CITY OF ALBUQUERQUE

October 31, 2023

**Re: Sandia Federal Credit Union
1100 Rio Grande Blvd. NW
30-Day Temporary Certificate of Occupancy
Transportation Development Final Inspection**
Engineer's Stamp dated 11-23-21 (H13-D109A)
Certification dated 10-23-23

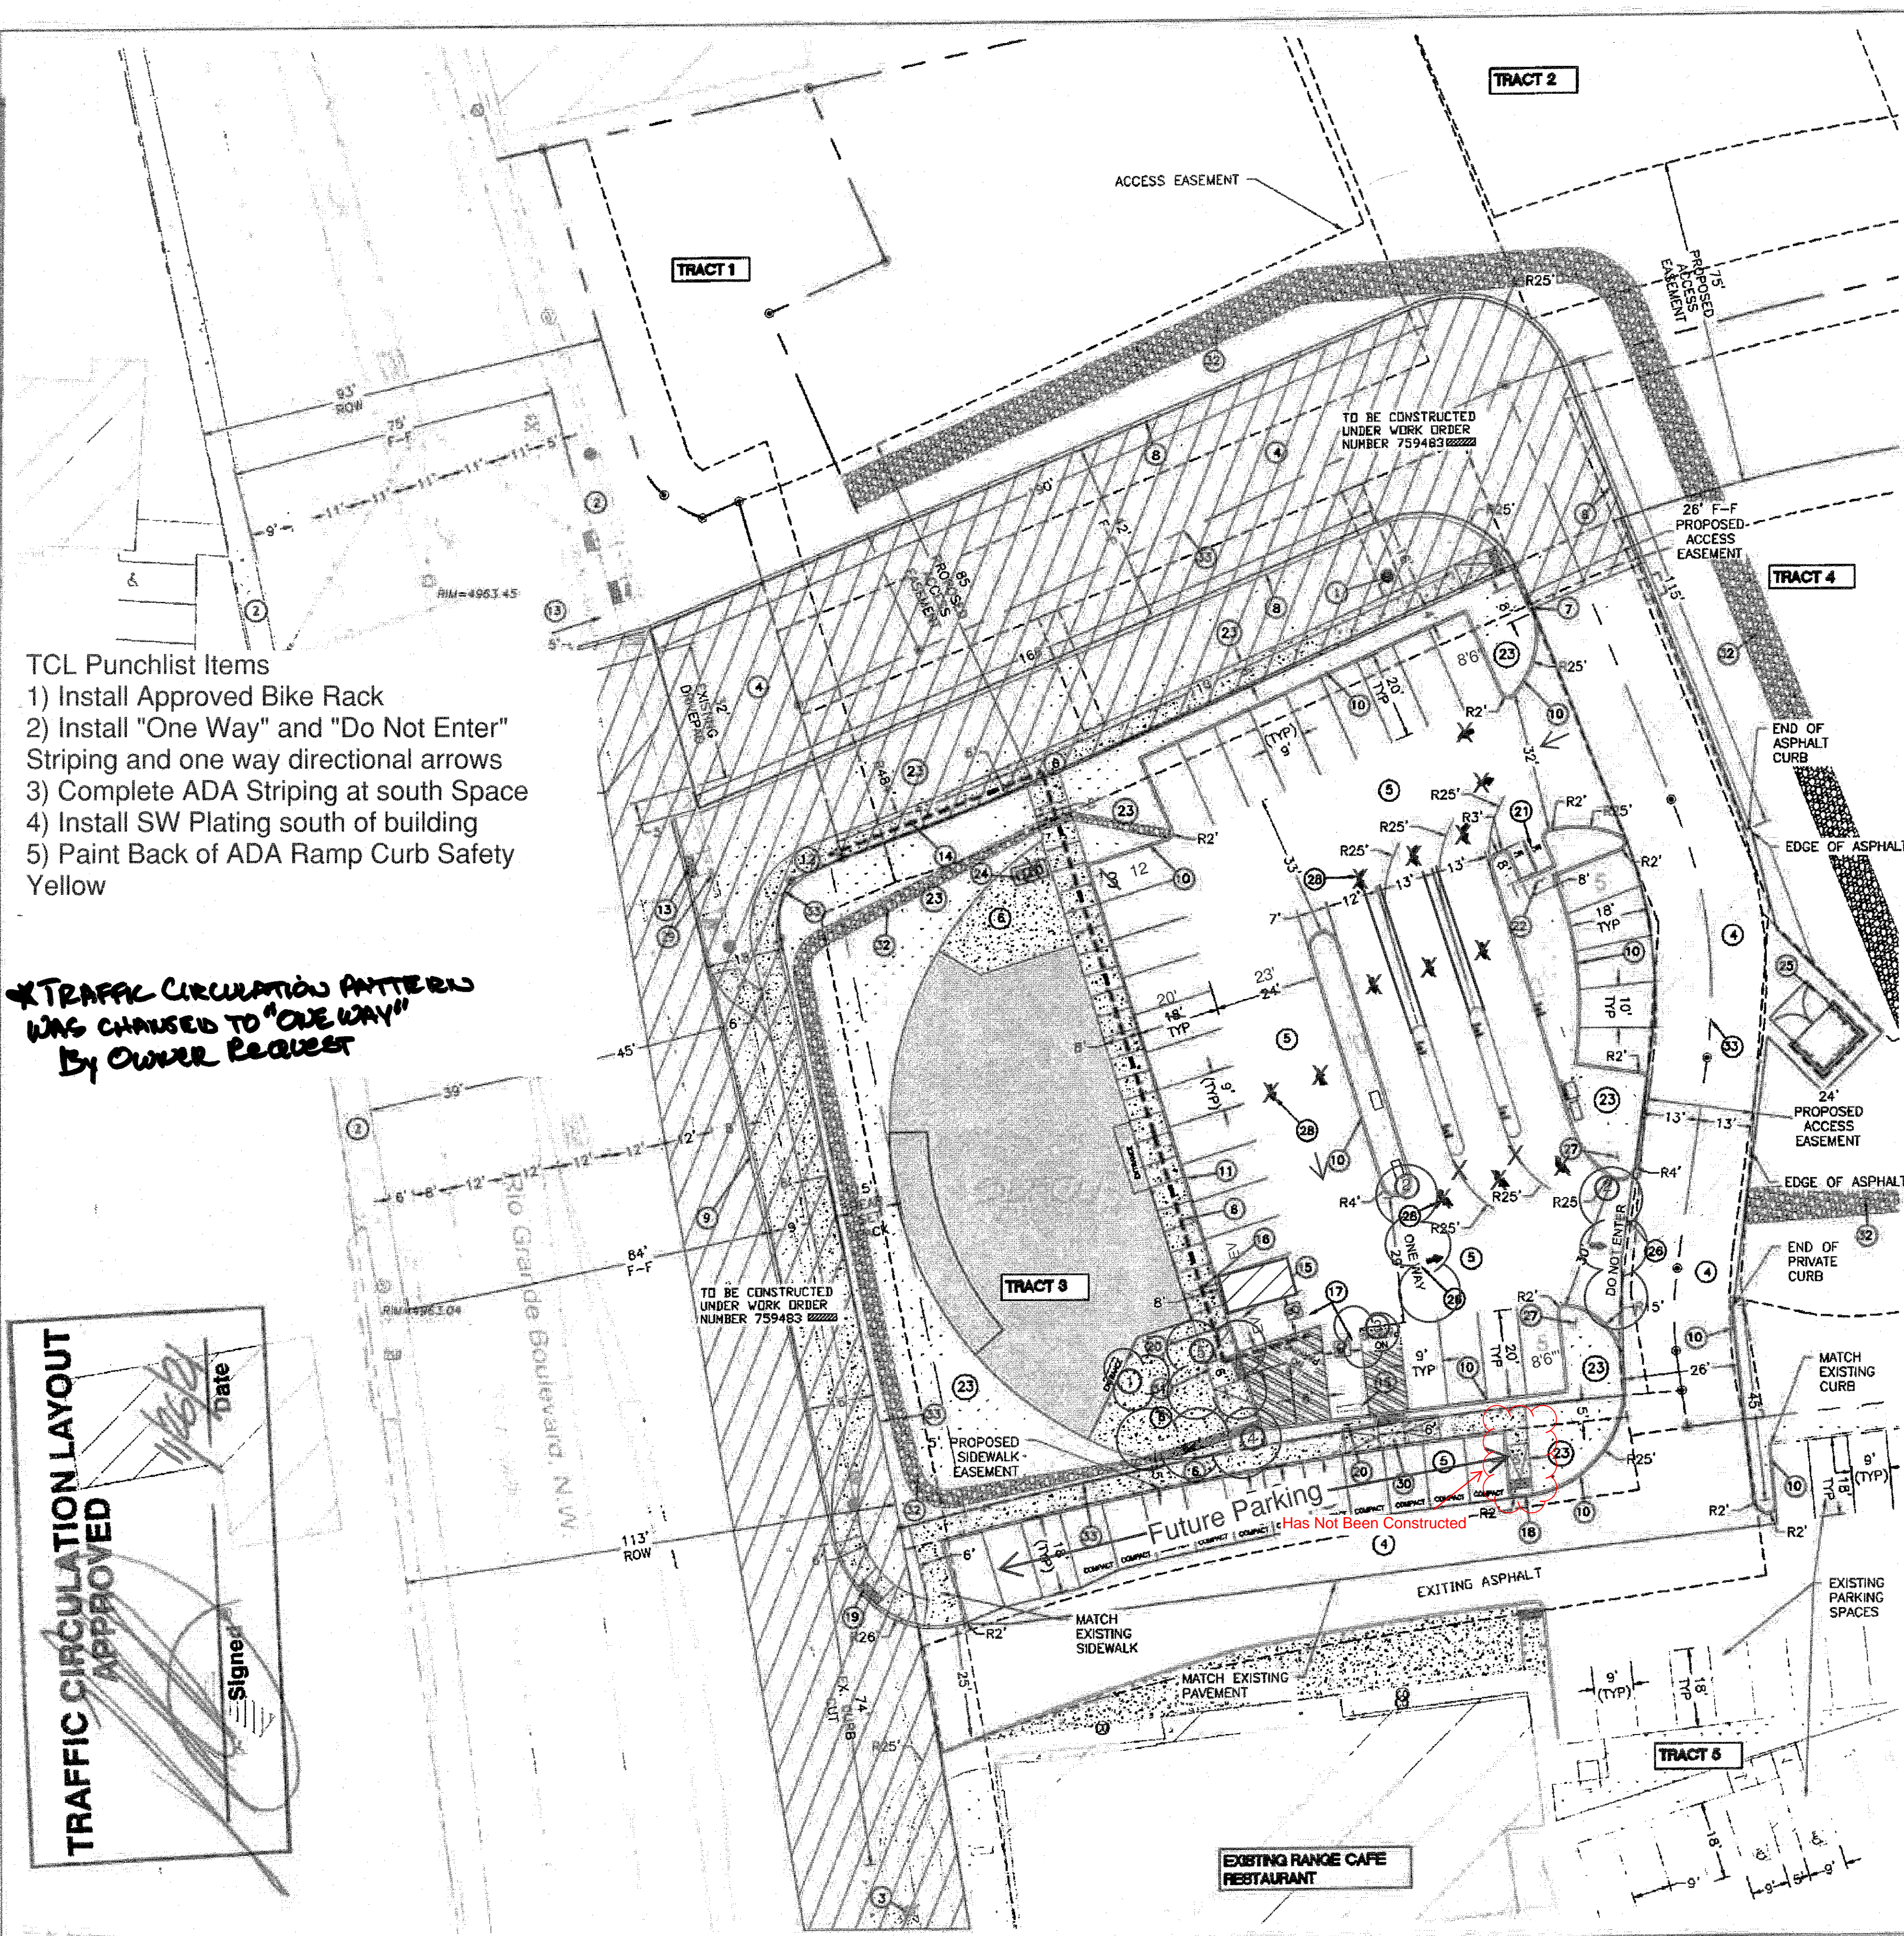
1. Because the sidewalk on the southeast side of the site has not been constructed, please red-mark the site plan with revision to reflect the as-built condition.
2. Per approved plan (details sheet), please provide hops bike racks. See attached details sheet.
3. Please complete the installation of the sidewalk culvert to ensure the safety of the pathway.
